Project Name: Acre Field

Planning Reference: Y_55_22_DOC

Formal Requests

25/05/2023 – Robert West Second Round Comments

Drawing Title : Fieldwork Location Plan

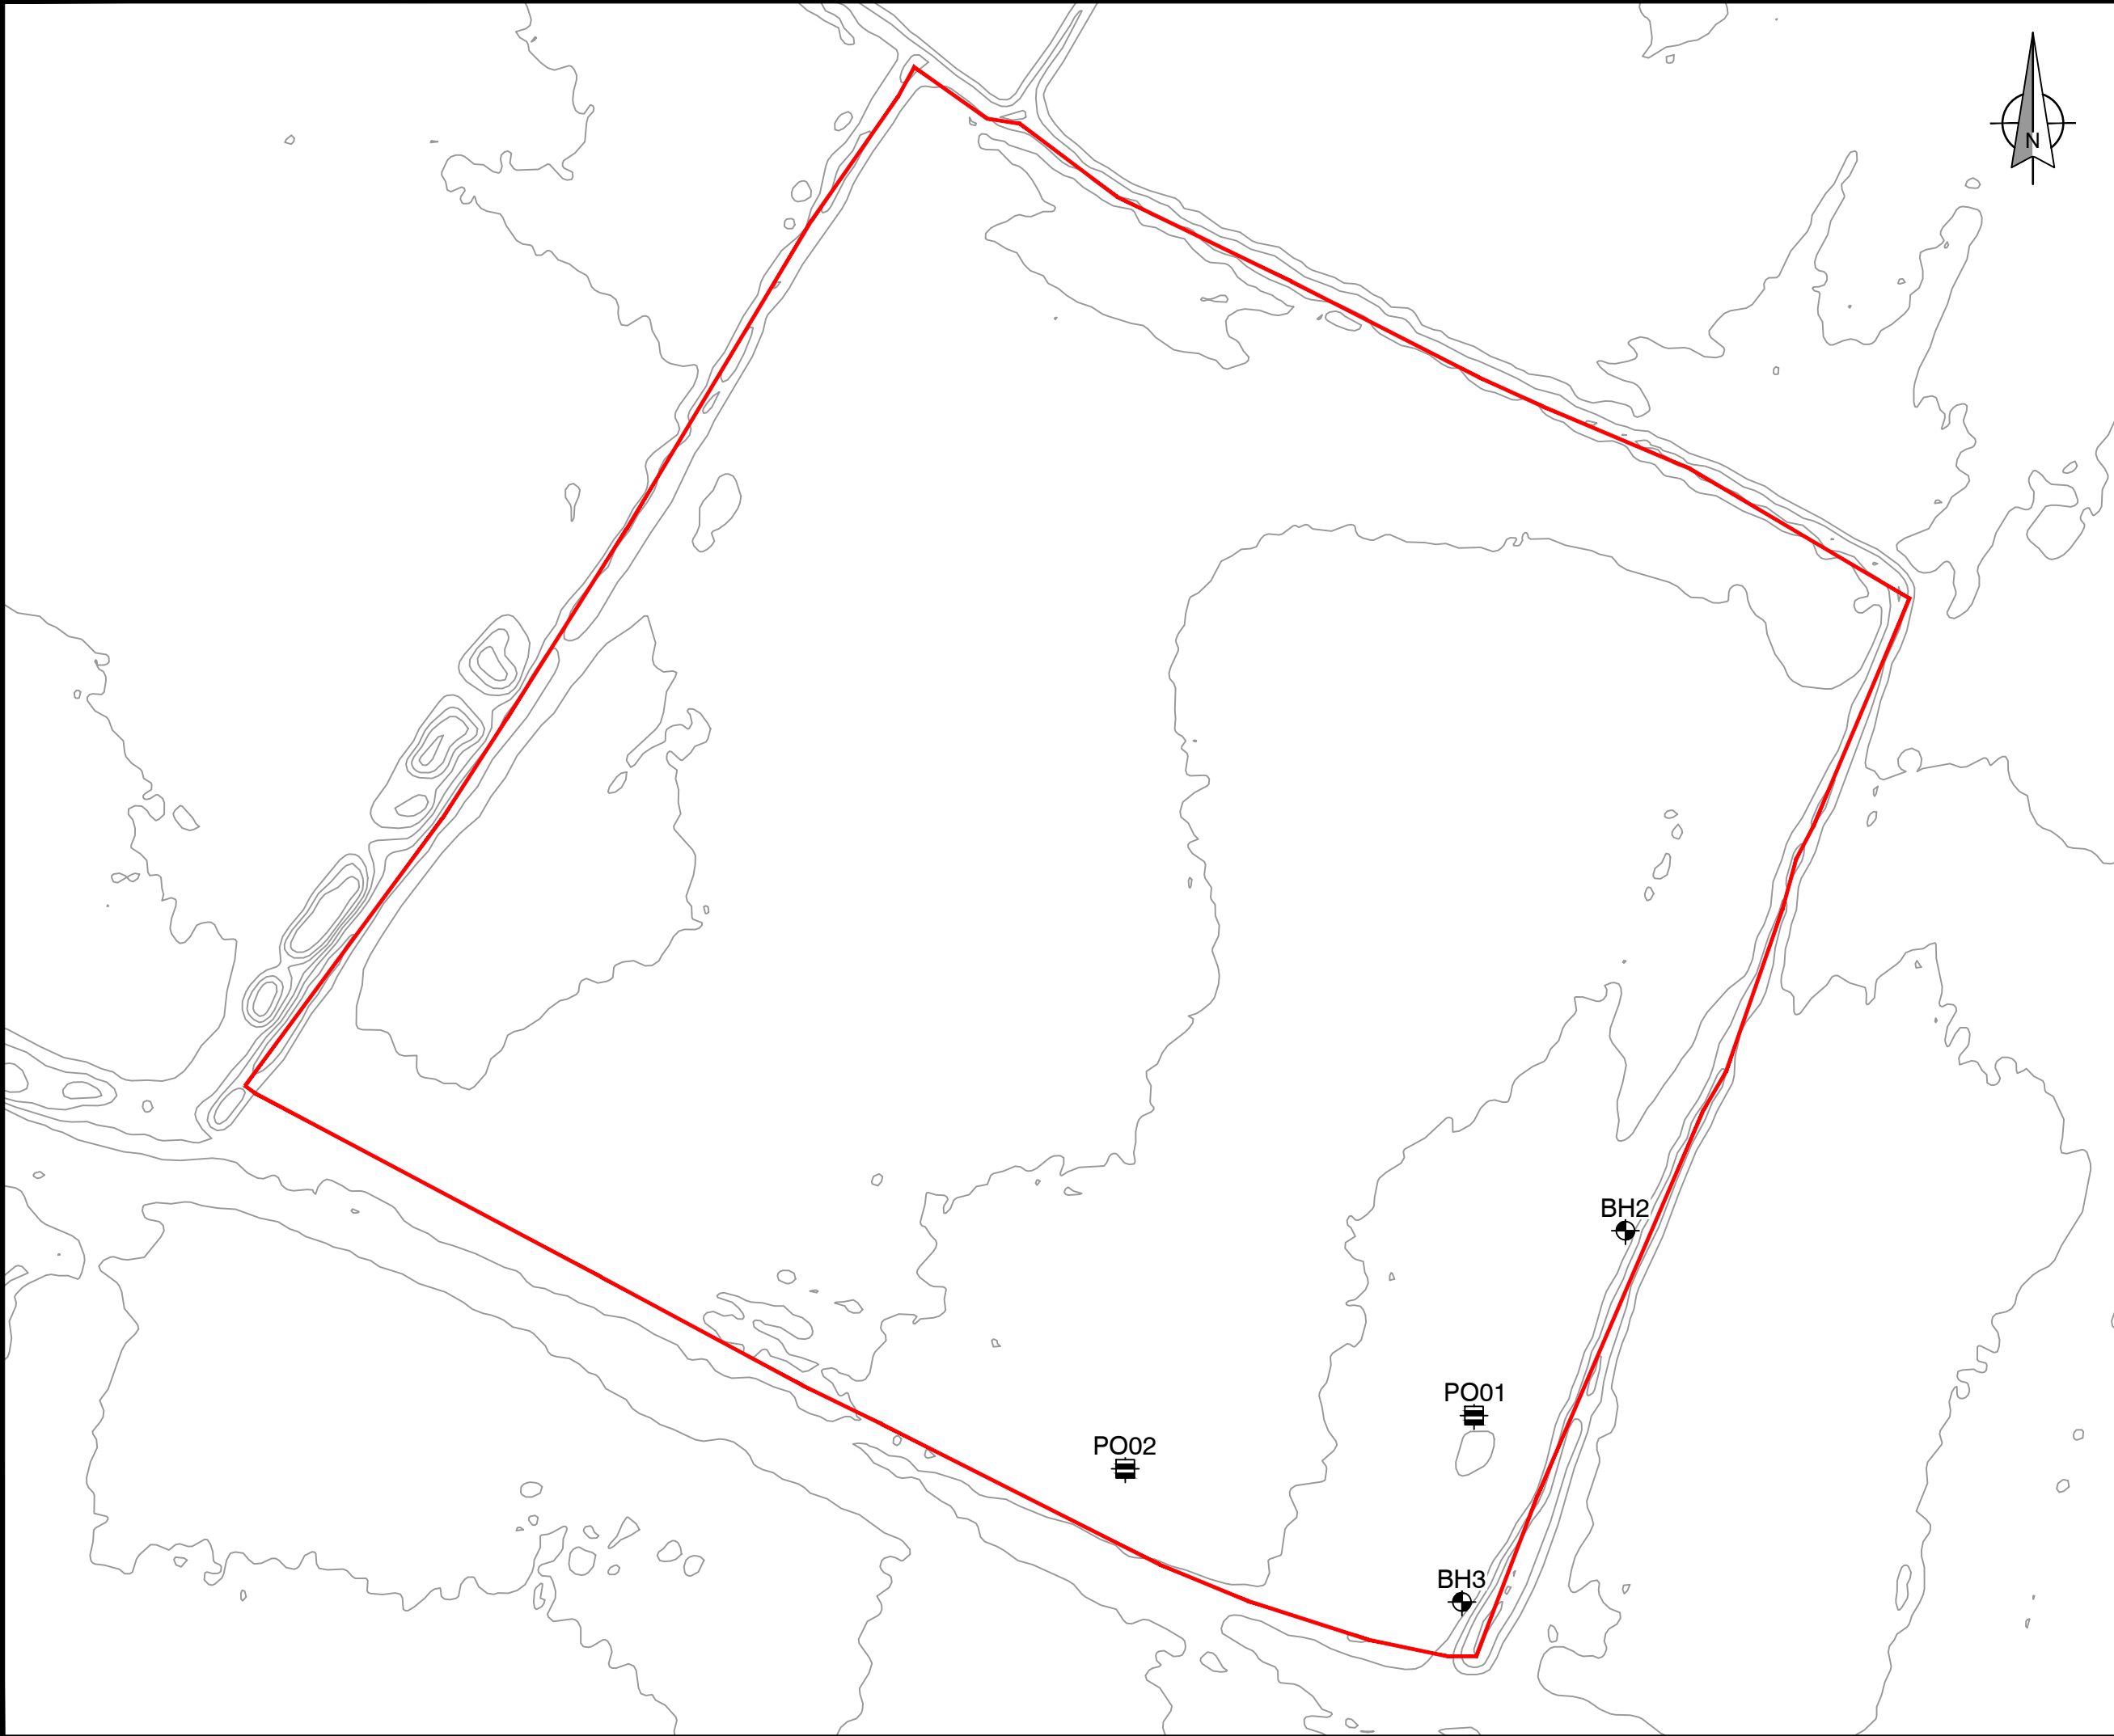
- Point 1 - Further information required:
 - i. Whilst reference has been made to the Factual Ground Investigation Report GL24235 by Harrisons dated May 2021, (ref. note 15, drawing CRH-XX-XX-DR-C-5050-P8_Proposed Drainage Layout (Sheet 1)), this information does not appear to have been submitted for review. The value specified in the applicant's response (infiltration rate of 2.37×10^{-6} m/s), has been applied to the model (calculation pack 0008 - utilising infiltration in the bases of the attenuation basin and the areas of permeable paving as requested). The results of groundwater testing have not been provided.

- Without the test results to verify the infiltration rates applied to model 0008, the results cannot be verified. This infiltration testing is required to confirm that infiltration rates at this location are sufficient to allow for runoff to discharge to the ground as designed. Providing the rates match the testing, the calculations provided are considered acceptable.

Infiltration testing supplied. Accepted.
